Mixed Use Dev, 23 Ocean Ave, Project #2016-1506 messages

Thank you for the opportunity to comment on the mixed-use development proposal (Project #2016-150) for 23 Ocean Avenue, Portland ME. My partner and I were unable to attend the meeting in person, but our neighbor shared the planning documents with us.

Drawing Title:  
**LANDSCAPE PLAN**

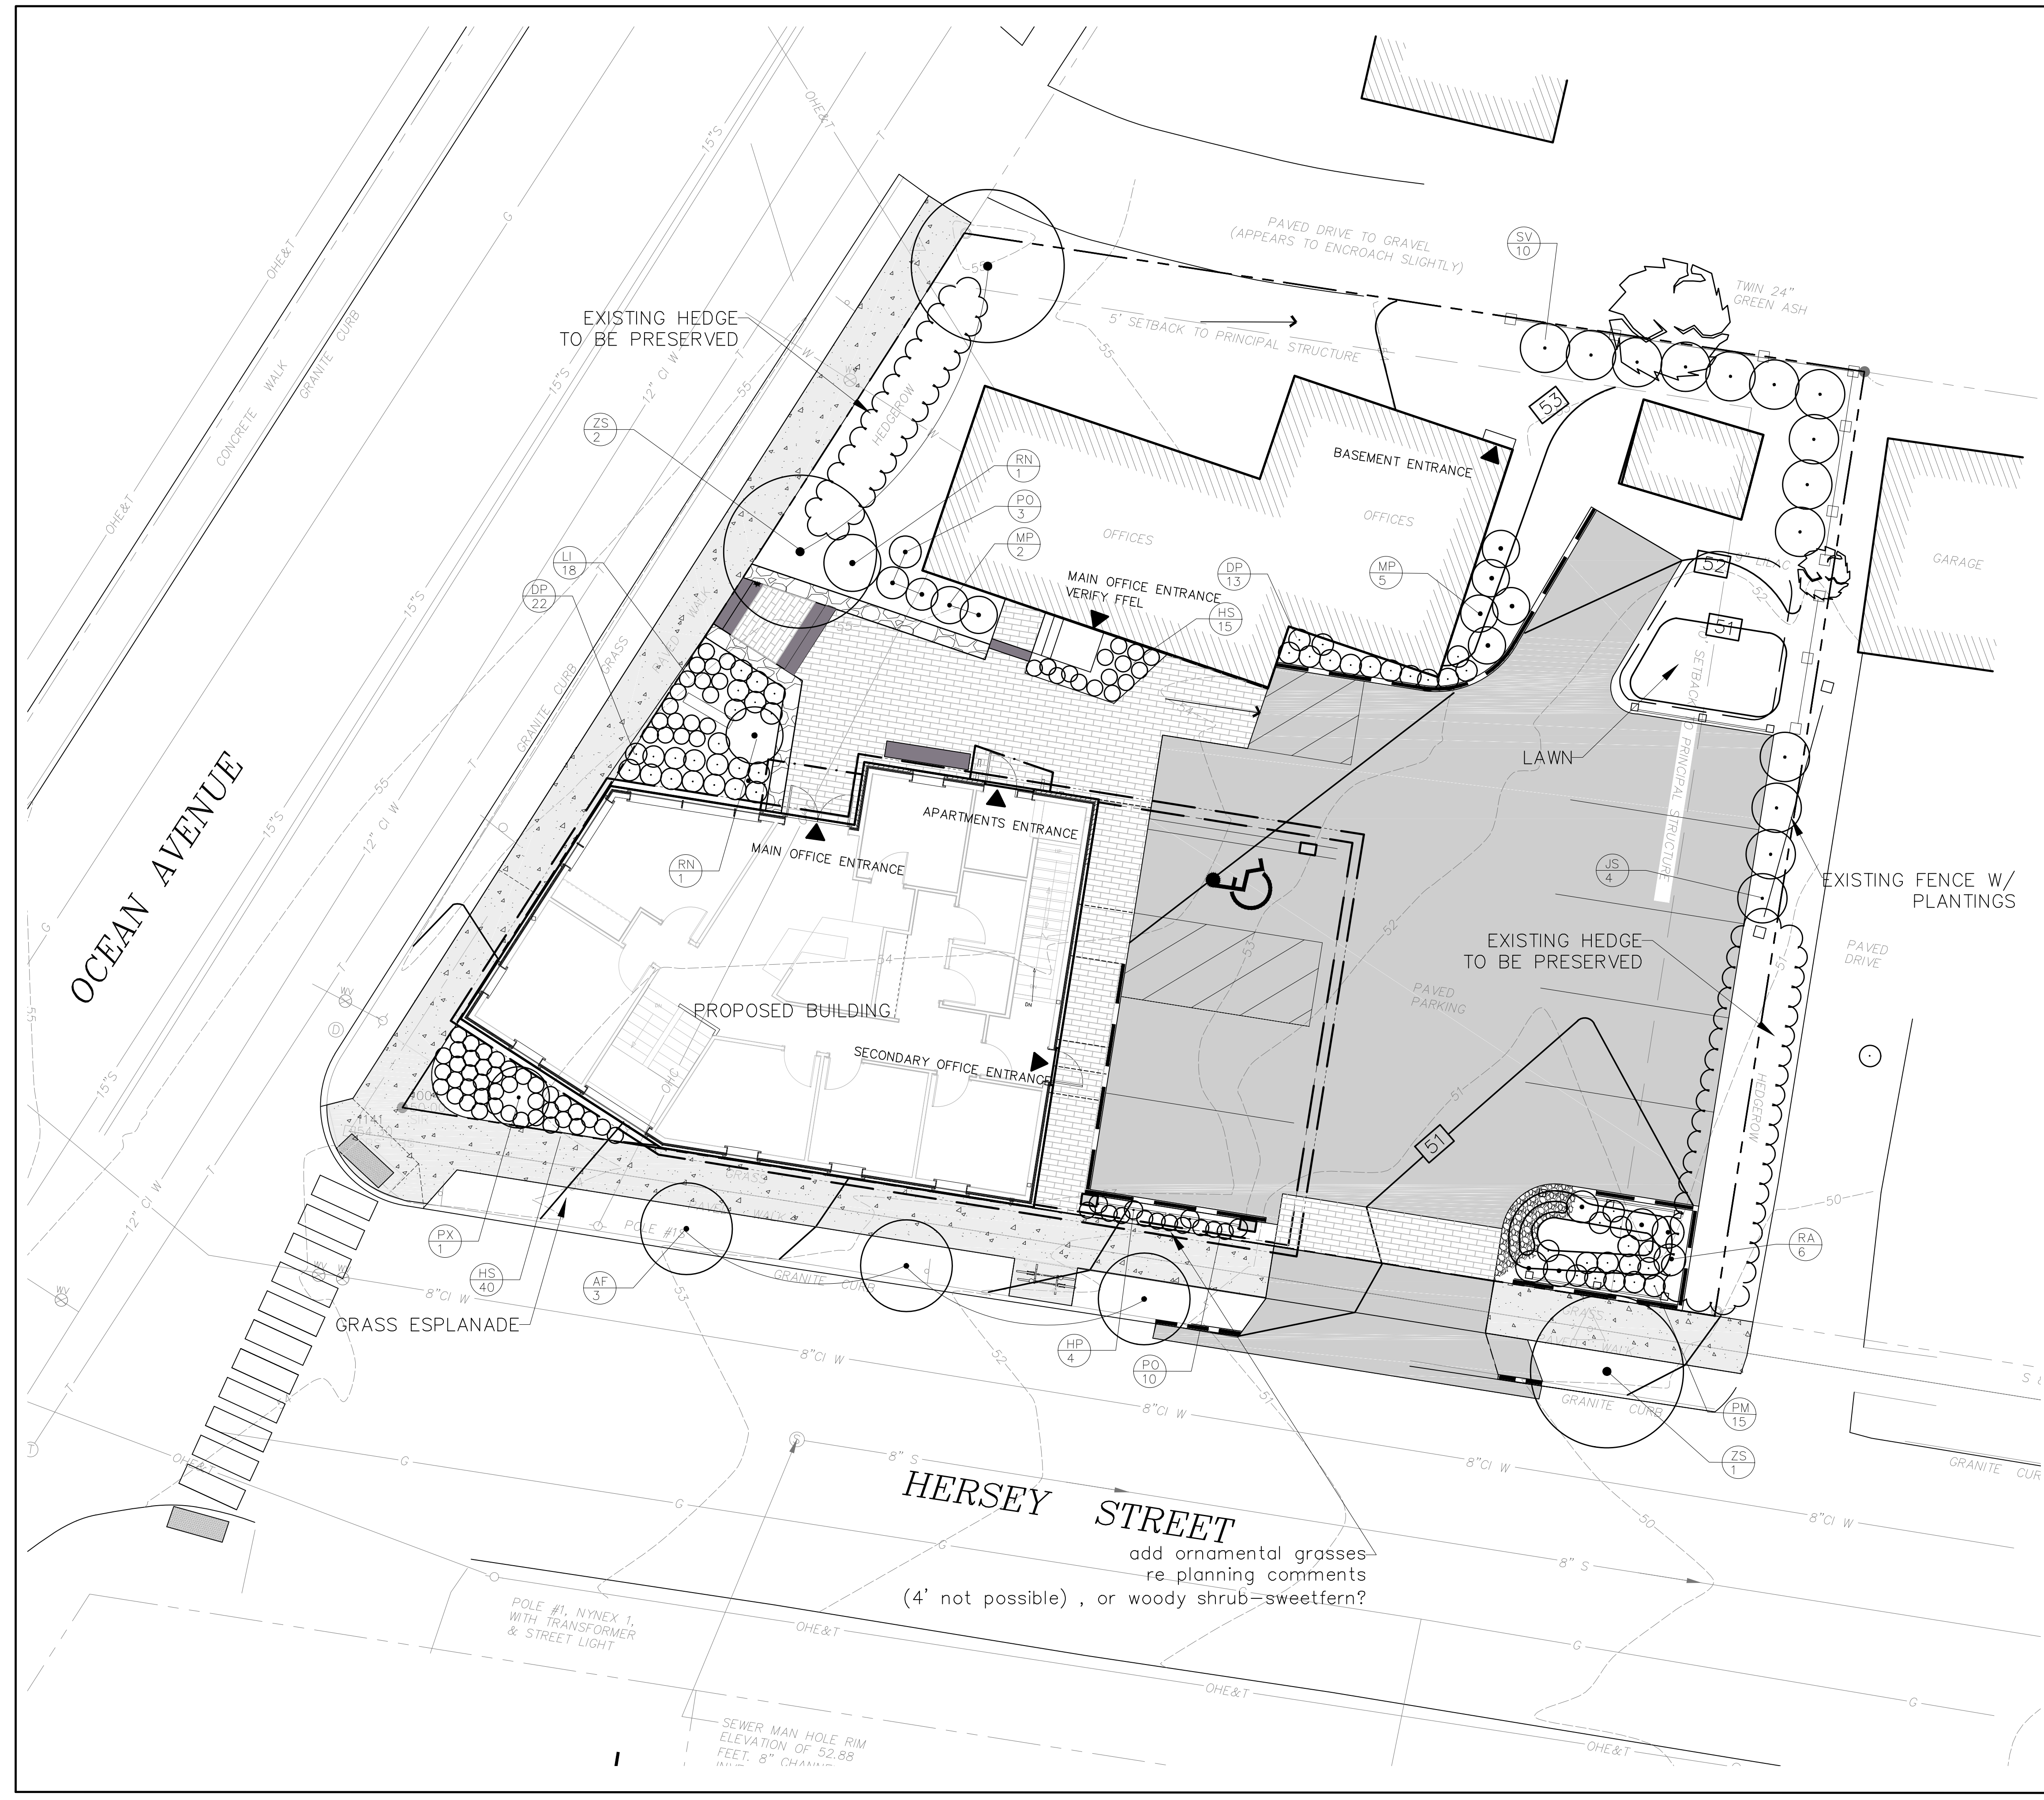
They are requesting a waiver to the flooding standard, and instead will manage stormwater through 'roof drains, a rain garden and pervious pavers'. The 'rain garden' appears as a minuscule plot — is it even five square feet? - jammed between the existing building, patio and proposed 7,000 square foot building. Another 'rain garden' of uncertain dimensions exists adjacent the parking lot, and is alleged to capture water runoff from the buildings' roofs.

City planners know that properties on the east end of Hersey Street (downhill from Ocean Ave) flood regularly even during moderate rainfalls. Removal of the big willow tree and the introduction of a large impervious surface will only exacerbate that problem.
